M54 to M6 Link Road
TR010054

**8.8 LIU(A) Draft Statement of Common
Ground with Allow Limited**

**8.8 LIU(A) Draft Statement of Common Ground with
Allow Limited**

Version	Date	Status of Version
1 (P02)	14/04/2020 (date issued to Allow)	S3
2 (P03)	02/11/2020	S8

Drawing Title
FIGURE 8.3:
PHASE I BASELINE HABITAT
SURVEY RESULTS

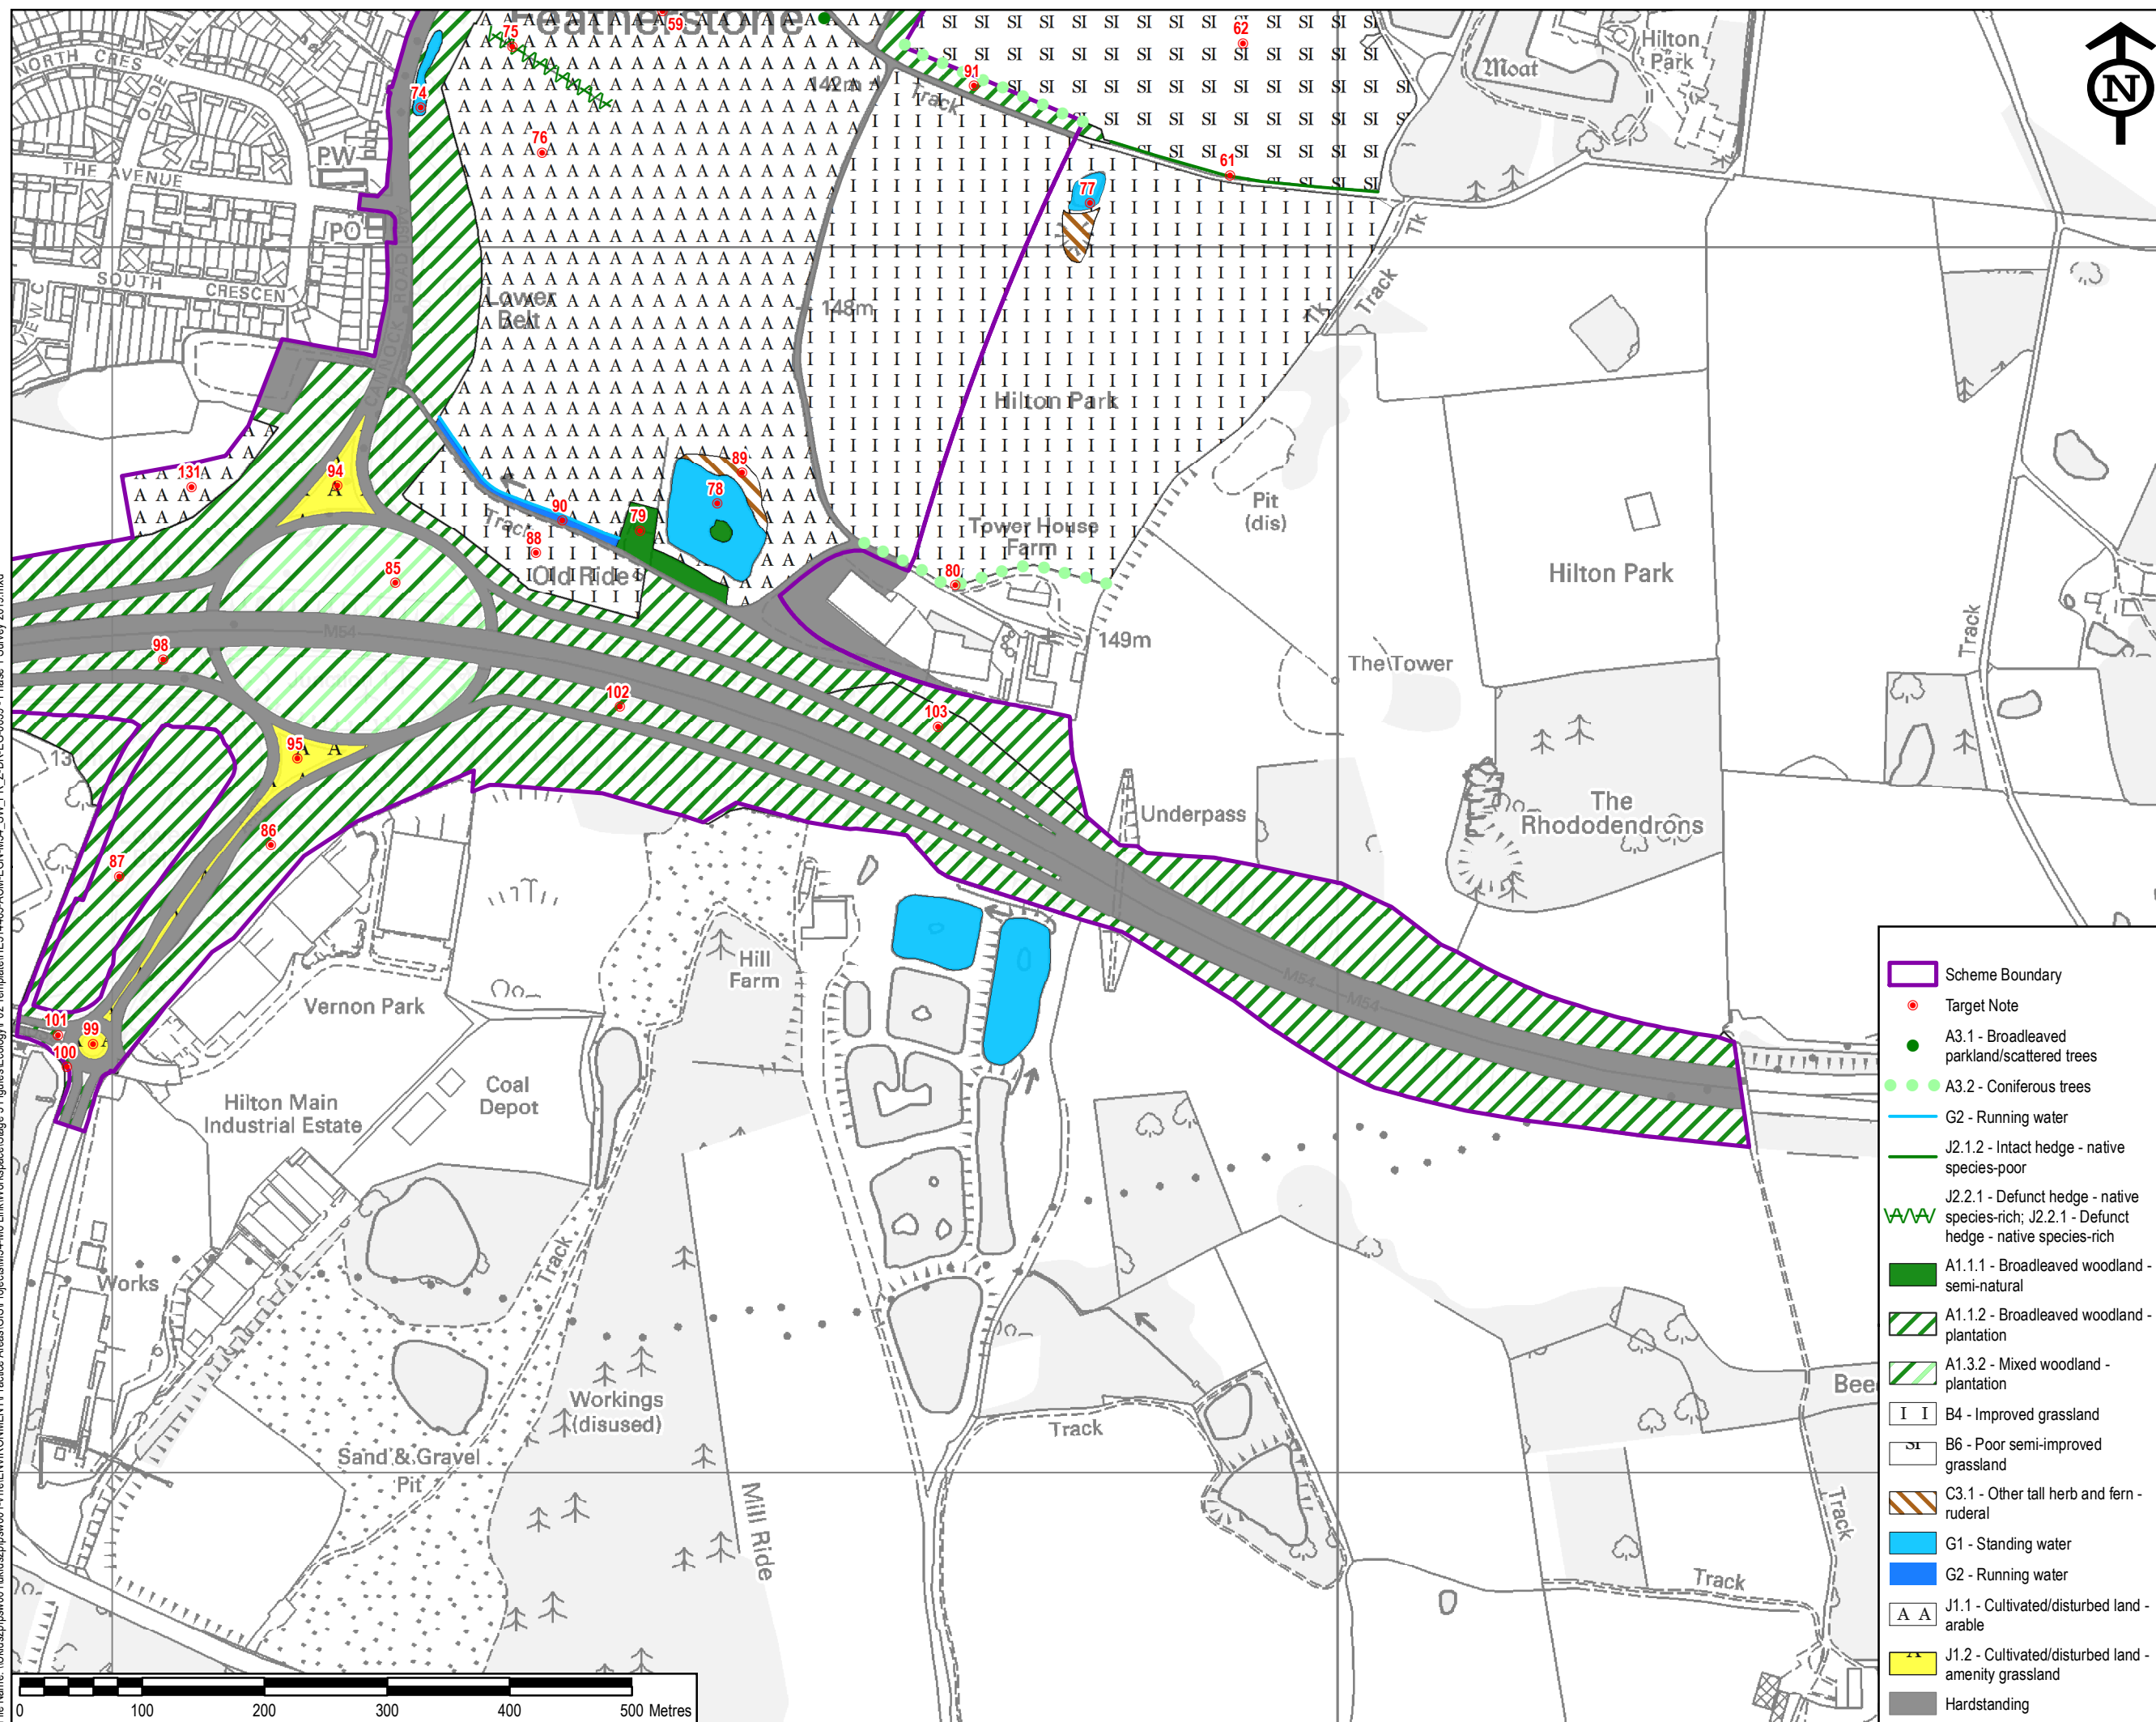
improved grassland (Figure 8.3 of the ES). By contrast, 'high' and 'moderate' levels of bat activity were recorded in the SBI and other areas to the east of the proposed scheme.				
SC31		<p>v. Following a review of the bat information, a number of key issues were identified, namely:</p> <p>a. Quantum of mitigation: Whilst acknowledging that woodland will be removed around Lower Pool SBI, across Allow's land holdings very little of the potential roosting habitat is being affected and only habitats of low importance for foraging bats are affected. Accordingly, the quantum of proposed mitigation is disproportionate for the effects on bat interests;</p>	<p>The levels of bat activity and the number of roosting features within Lower Pool LWS/SBI are not the principal factor for the quantum of woodland planting being created on Allows land.</p> <p>The scale of the mitigation (providing 4.94ha of woodland planting, and 0.57ha of standing water surrounded by 0.78ha of grassland for the loss of 2.04 ha of woodland and 0.46 ha of standing water within Lower Pool LWS/SBI) is proportionate to the impact, given that the LWS is of county nature conservation importance and new woodland planting will take 30+ years to establish and mature.</p>	Under discussion	Medium

FIGURE 8.18:
BAT BASELINE-TRANSECT ACTIVITY
SURVEY RESULTS (2018 AND 2019)
2 OF 3

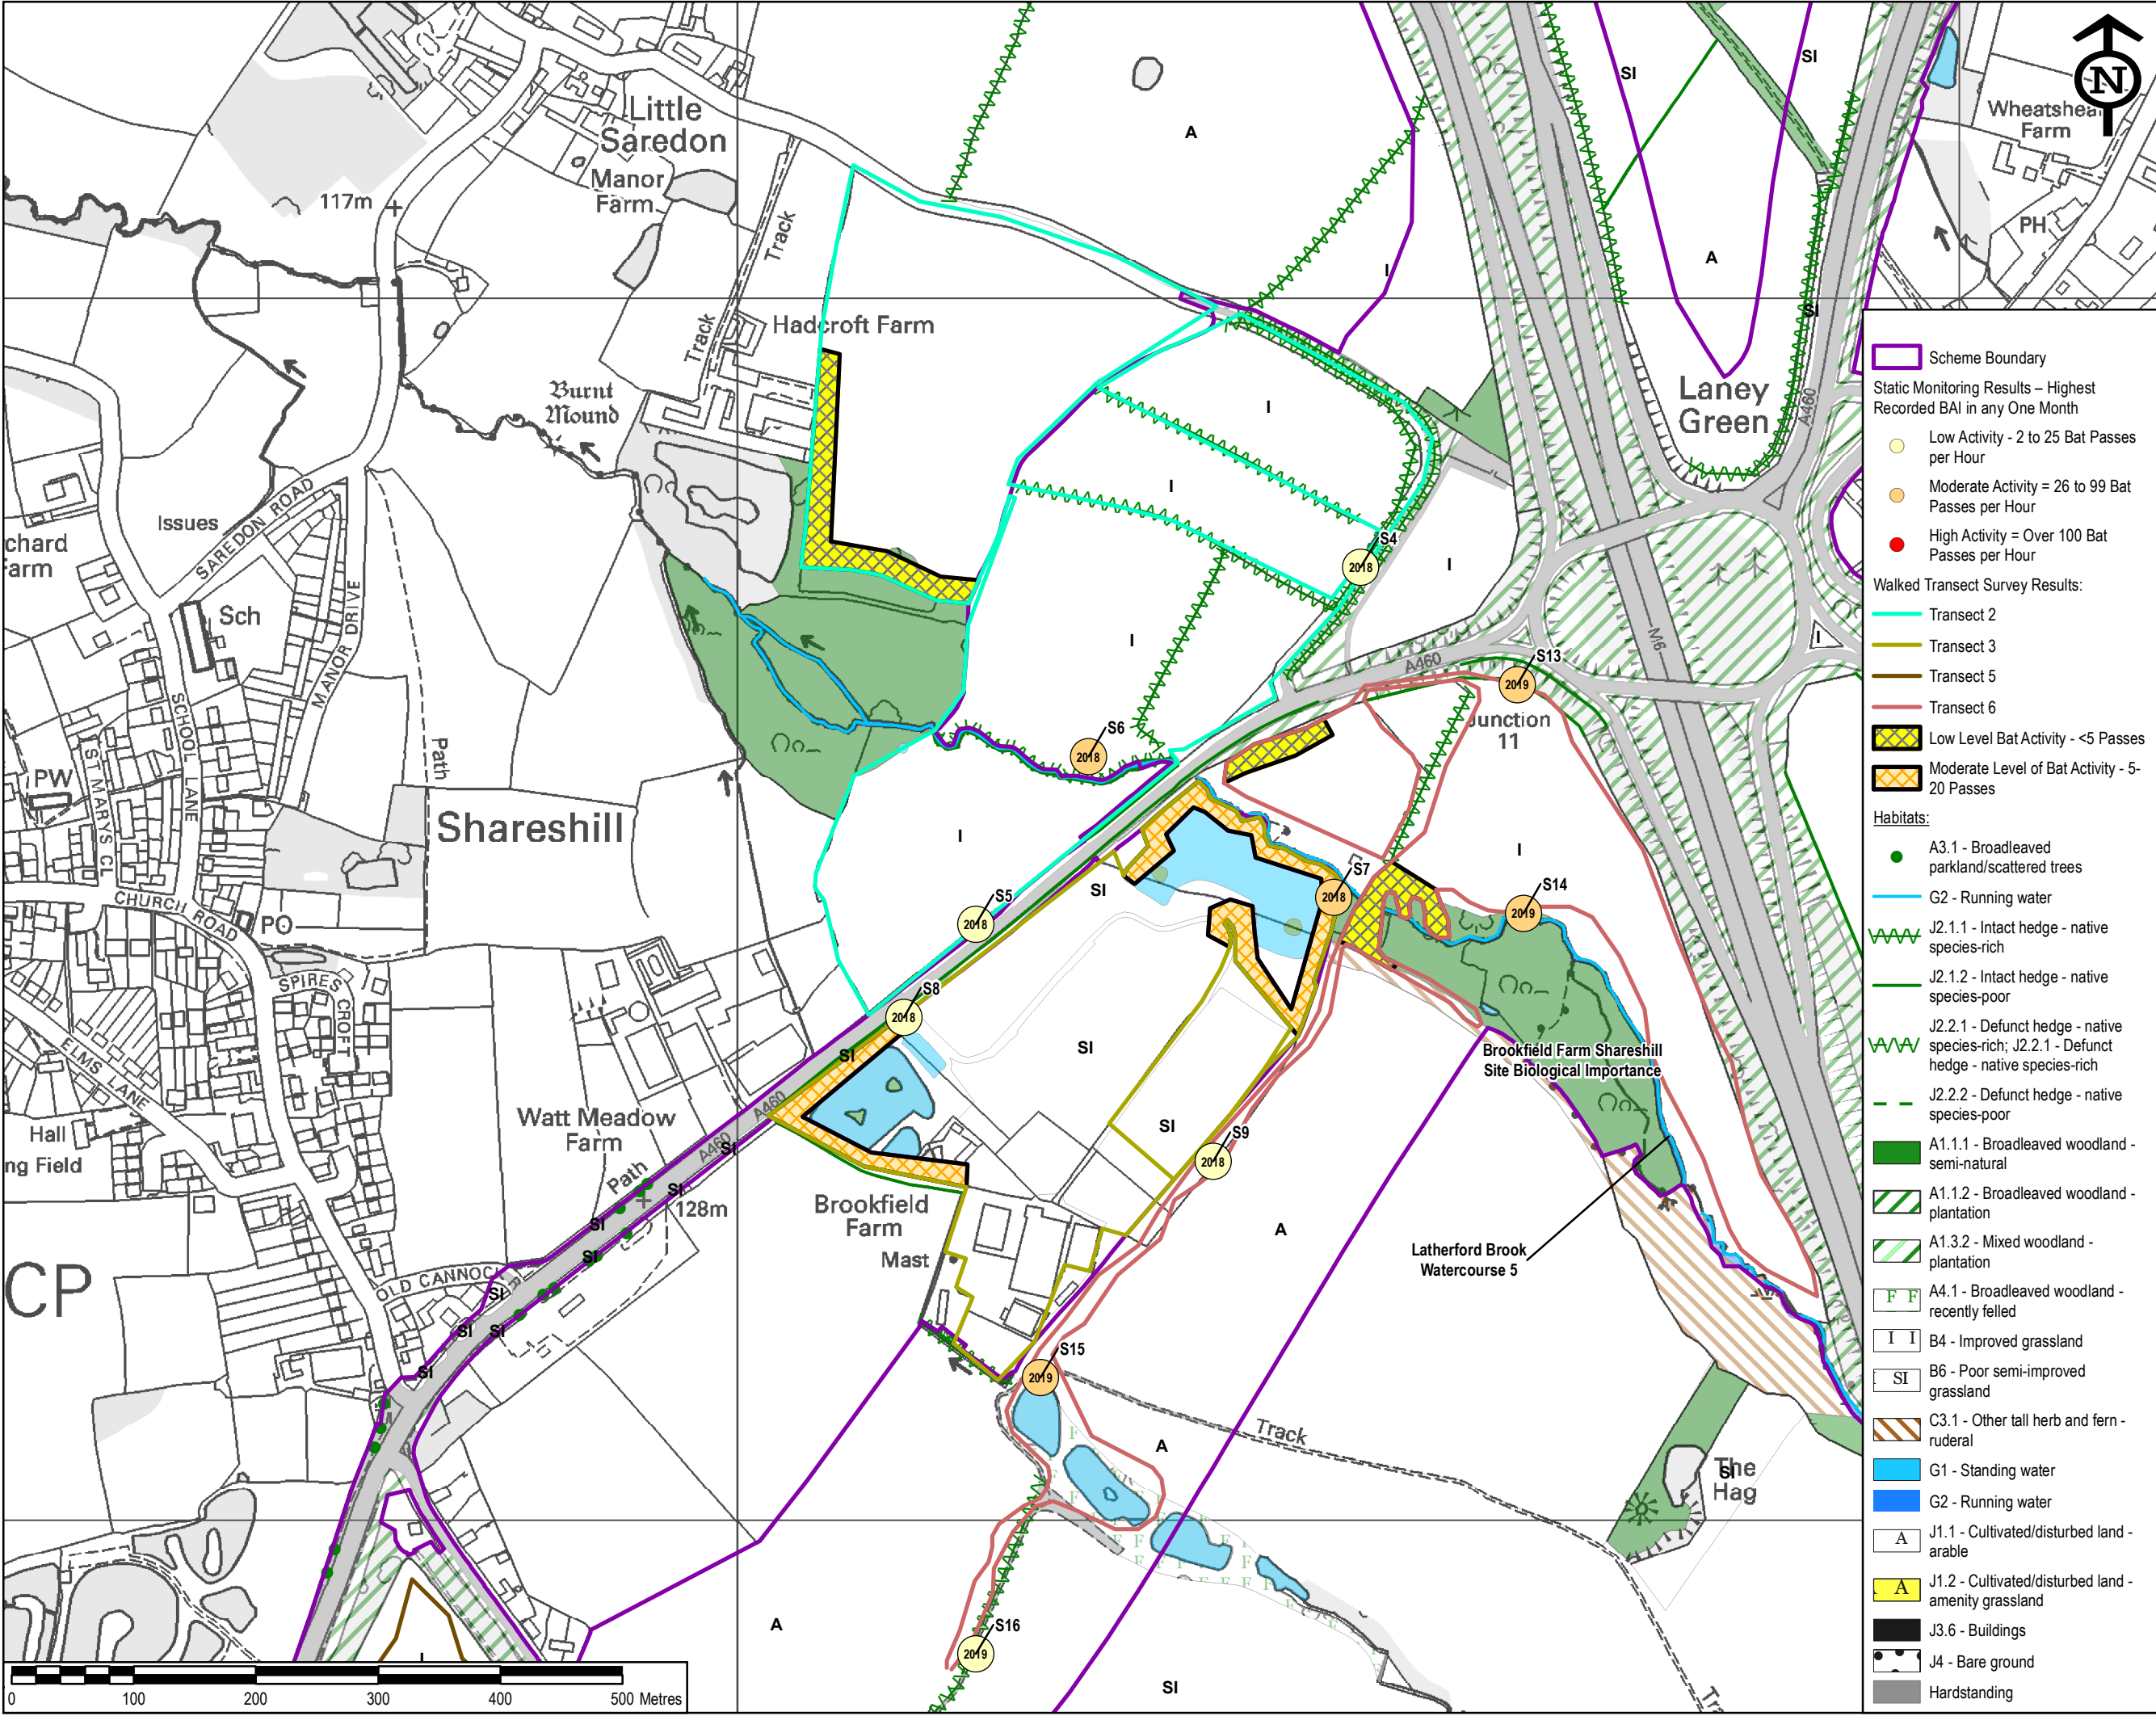
SC37		<p>vi. Surveys have identified that bat activity levels are greater to the east of the scheme on Allow's land holdings (see Figure 8.18 of the ES). Provision of mitigation to the west of the Link Road is unlikely to be as functionally valuable (as it would not link with the existing habitat resource in the east) and would be isolated by the link road itself.</p>	<p>As bats will be able to safely cross the road in this location the new compensation planting is not considered to be isolated from the retained habitats within Lower Pool. As the woodland west of the scheme develops it has the potential to provide new foraging habitat for bats.</p>	Under discussion	Medium
